AIR NAVIGATION, AIRSPACE AND AERODROMES BRANCH

CASA Ref: F24/8405-2
Your Ref: SSD-30448824 Email of 11 July 2024

CASA ASSESSMENT – JUNCTION RIVERS WIND FARM SSD-30448824

CASA has reviewed the Aviation Impact Assessment (AIA) (Appendix 18 to the EIS) by Aviation projects of 13 May 2024 for the proposed Junction Rivers Wind Farm.

Figure 1. Aviation Obstacle Lighting Plan (Source: Aviation Projects, 2025)

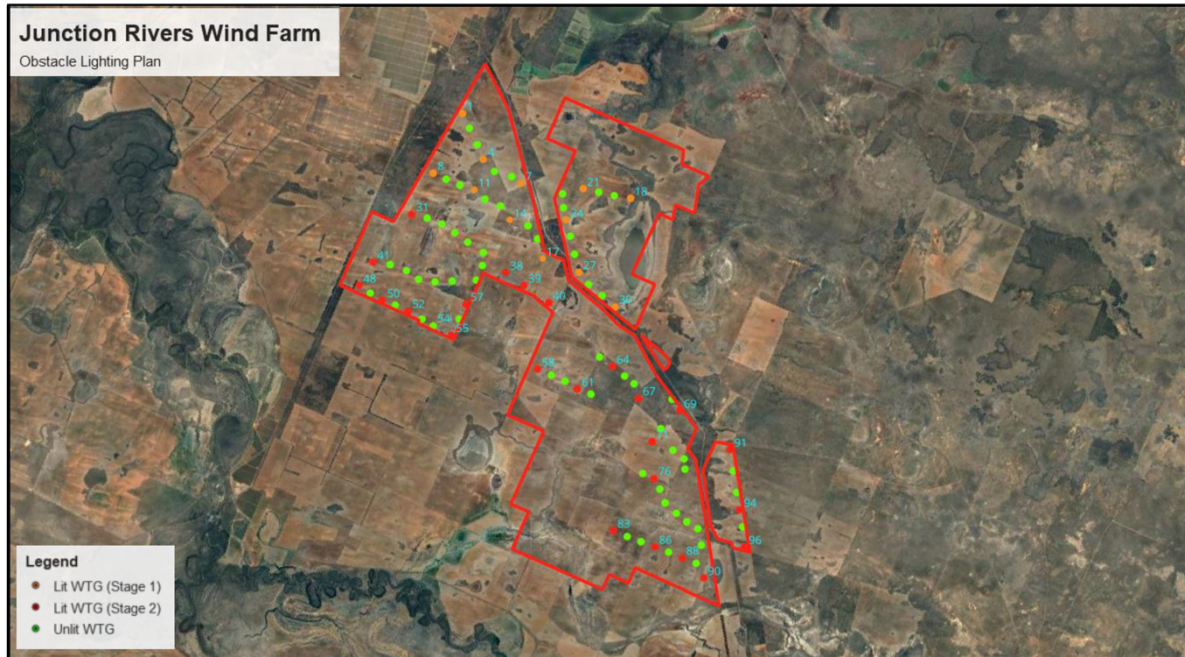
Contrary to Recommendation 9, CASA considers the proposed wind farm will be a hazard to aviation safety and recommends that the wind farm is obstacle lit with steady medium-low intensity red obstacle lighting in accordance with the National Airports Safeguarding Framework Guideline D '*Managing the Risk of Wind Turbine Farms as Physical Obstacles to Air Navigation*' [National Airports Safeguarding Framework Principles and Guidelines \(infrastructure.gov.au\)](https://www.infrastructure.gov.au/national-airports-safeguarding-framework-principles-and-guidelines) and section 9.31 of Part 139

International standards require 2,000 candela lighting intensity on the nacelle (also recommended in the NASF guideline) and 200 candelas at the mid-point of the turbine mast. CASA recommends that 200 candela as a minimum intensity lighting on the nacelle would suffice (due mainly to the lack of background lighting in the vicinity of the turbines). The obstacle lighting should be monitored to alert the wind farm operator of any outage and at least some of the obstacle lights remain on during an outage. CASA is prepared to review a lighting plan that indicates which turbines are proposed to be lit.
